RE: 6/2018/0642/VAR – 37 Broadwater Road, Welwyn Garden City, AL7 3AX

Thank you for consulting us on the above application for the variation of condition 16 (approved plans) on planning permission 6/2016/2497/MAJ, dated 27/04/2017, at 37 Broadwater Road, Welwyn Garden City, AL7 3AX.

drawing title
PROPOSED SITE PLAN

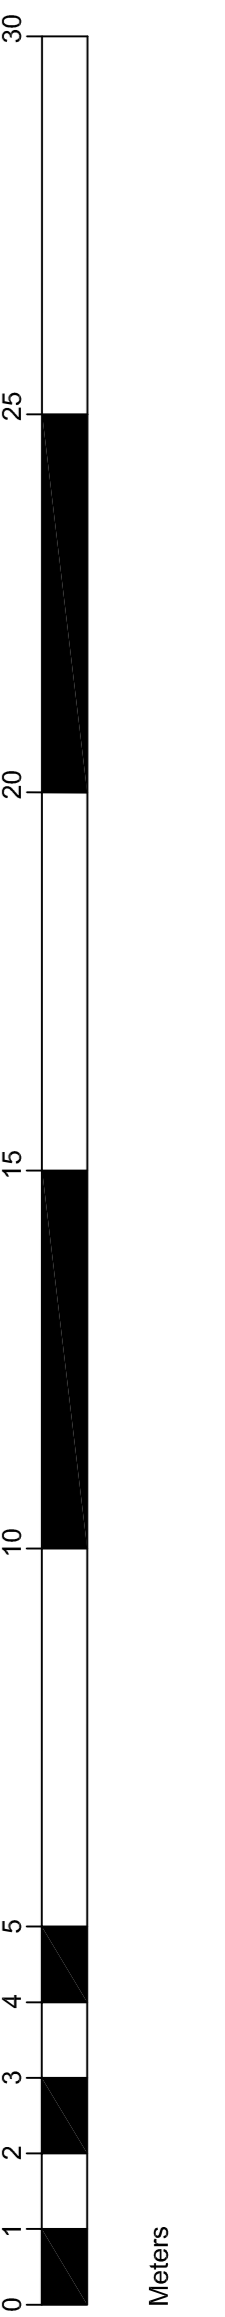
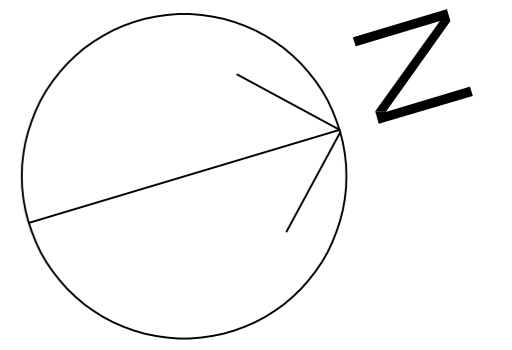
However, we have noticed that the applicant is proposing now a Single PLY Roof. If this will impact the approved drainage strategy on the development site, the LPA should seek a clarification from the applicant. The LPA should make sure that the approved drainage strategy will be implemented on the site.
